Gatwick Airport Northern Runway Project

Statement of Common Ground Between Gatwick Airport Limited and Tandridge District Council – Tracked Version

Application Document Ref: 10.1.9

PINS Reference Number: TR020005

Diagram 3.3.9: Model performance before and after adjustment, London zone

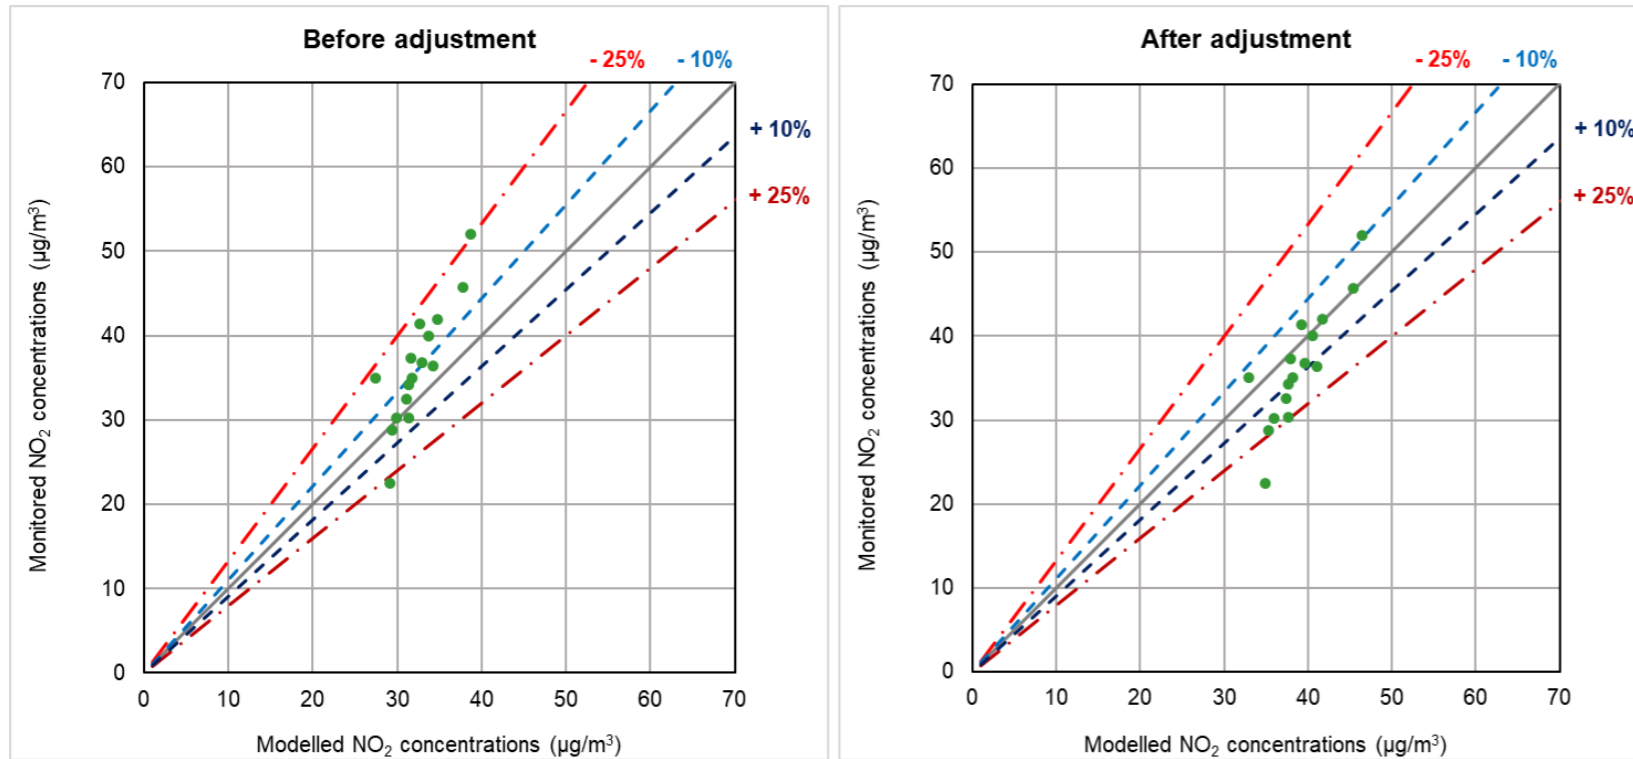
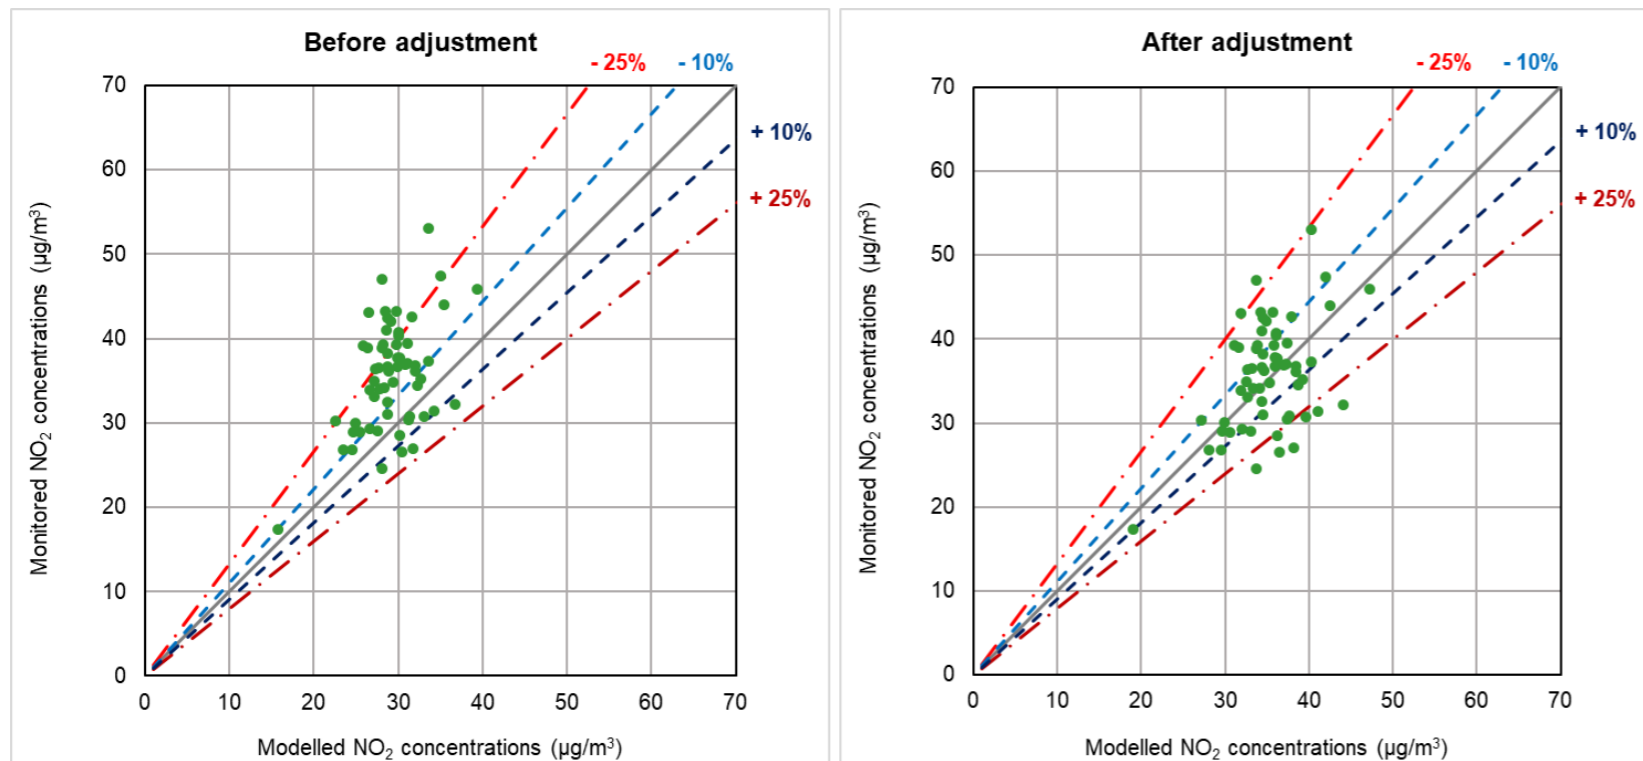
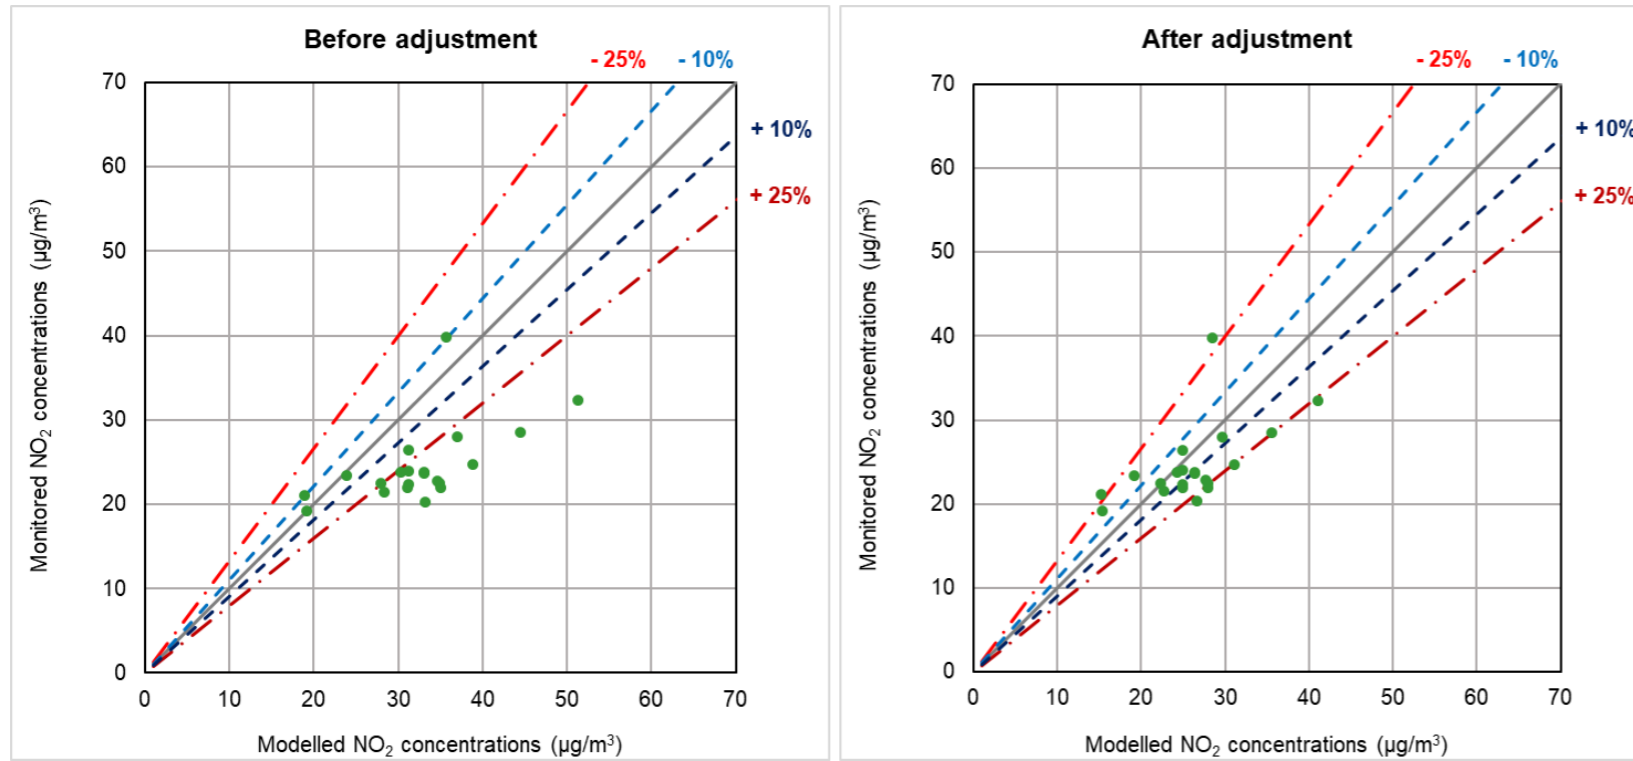
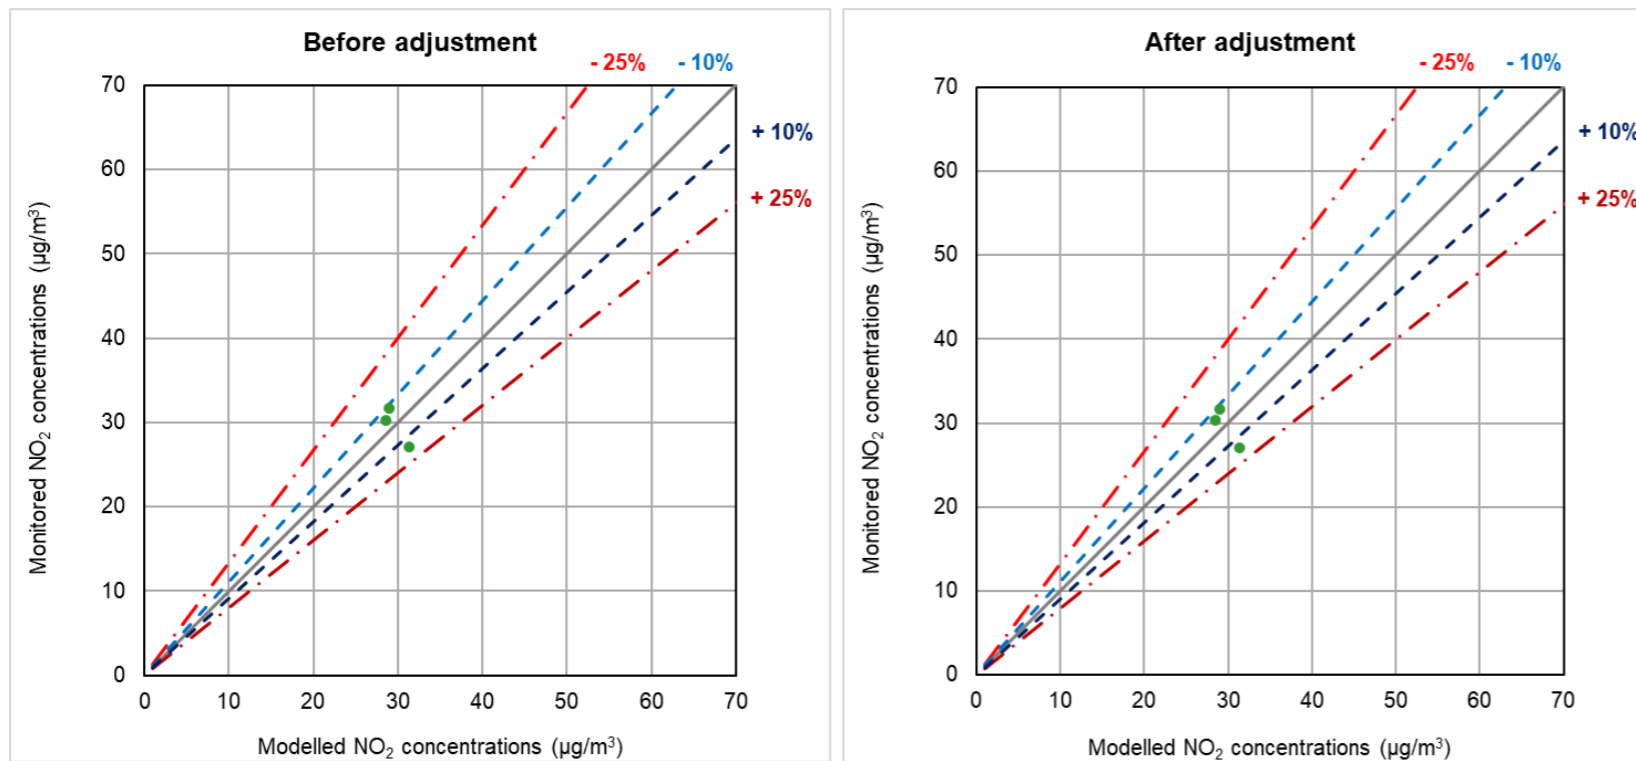
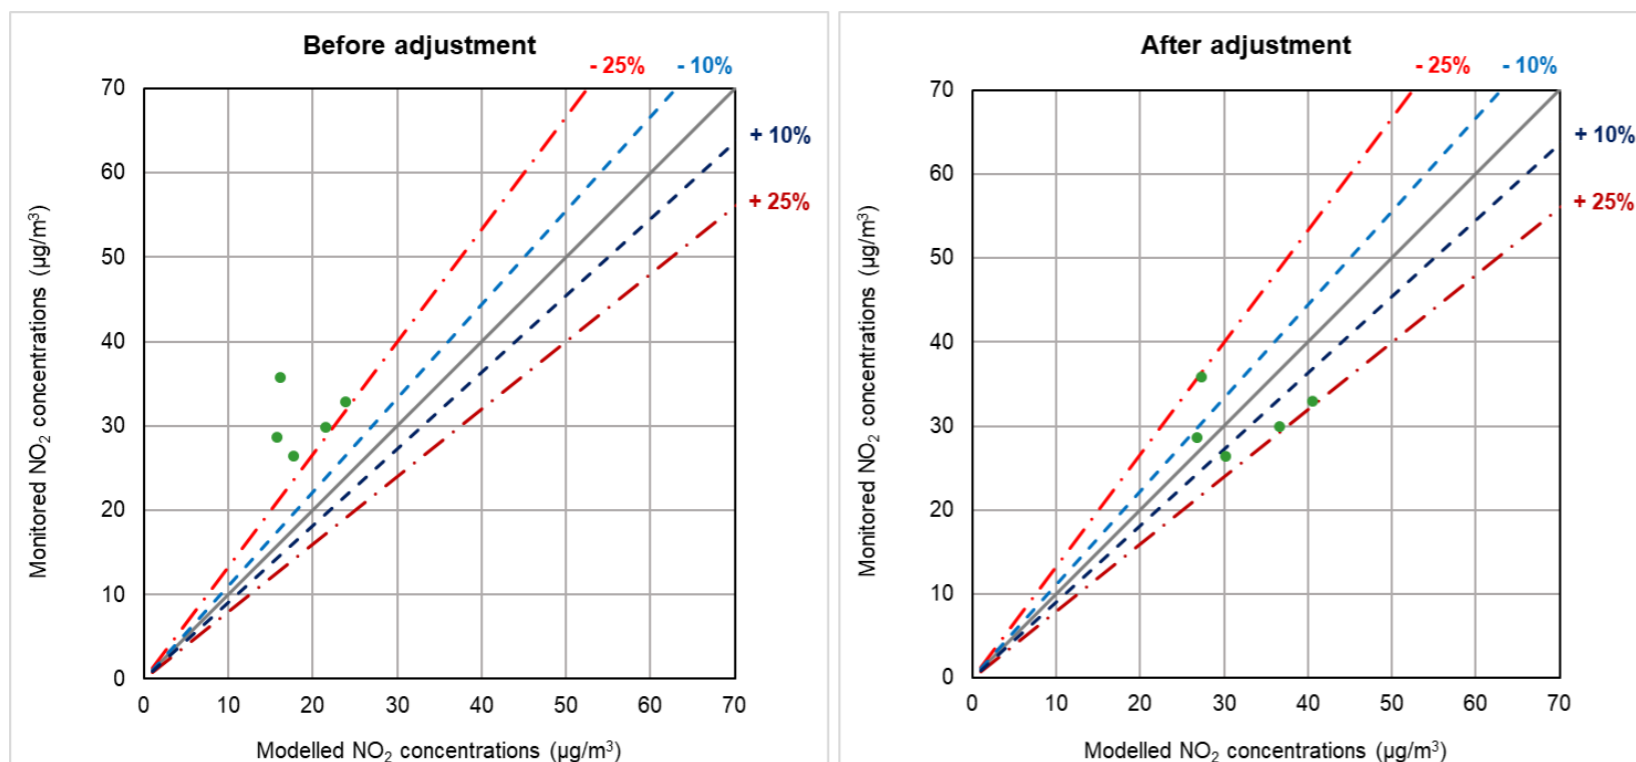
2.2.2.5	Verification zones	<p>TDC disagrees that enough justification was provided for the selection of different verification zones and why the model would be expected to perform differently in each area. A sensitivity test is required to demonstrate that the conclusions of the assessment would not change if a single verification factor were used.</p> <p>Updated position (Deadline 1): Further discussion is required on this point and the request for a sensitivity test examining the use of a single verification factor still remains.</p> <p>Updated position (Deadline 5): Gatwick Airport Limited (GAL) comments in paragraph 3.7.7 of their Response to Deadline 3 Submissions [REP4-031] that the air quality matters submitted by the Joint Local Authorities at Deadline 3</p>	<p>Full details of the model verification process are included in Section 3 within the ES Appendix 13.6.1. Table 3.3.1 provides details on the verification zones used.</p> <p>The verification methodology was agreed with local councils at the modelling methodology workshop in November 2022. Model files and results were provided to the TWG via email 18th August 2023.</p> <p>The process followed during the ES took into account feedback from the local authorities at the PEIR stage and following discussions on the agreed approach.</p> <p>Updated position (April 2024): The Applicant notes that the JLAs have provided a submission on air quality at Deadline 3.</p>	<p>ES Appendix 13.6.1 Air quality Data and Model Verification [APP-159],</p> <p>Appendix A: Response to West Sussex Joint Local Authorities – Air Quality to The Applicant’s Response to Deadline 4 Submissions</p>	<p>Under discussion Agreed</p>

(Appendix A) [REP3-117] will be responded to by Deadline 5. This Appendix of air quality queries prepared by AECOM included a wide range of technical matters.	The Applicant will review this submission and respond accordingly. Updated position (Deadline 5): The Applicant has provided a response to the air quality matter submitted by the JLAs at Appendix A: Response to West Sussex Joint Local Authorities – Air Quality to The Applicant’s Response to Deadline 4 Submissions (Doc Ref. 10.38). The Applicant will respond at Deadline 6 to the JLAs’ review submitted at Deadline 4 [REP4-053]. <u>Updated Position (July 2024): This matter can be marked as ‘agreed’ following consultation with AECOM on behalf of the local authorities on the technical queries set out at Deadline 5 [REP5-073].</u>	<u>[REP5-073]</u> (Doc Ref. 10.38)
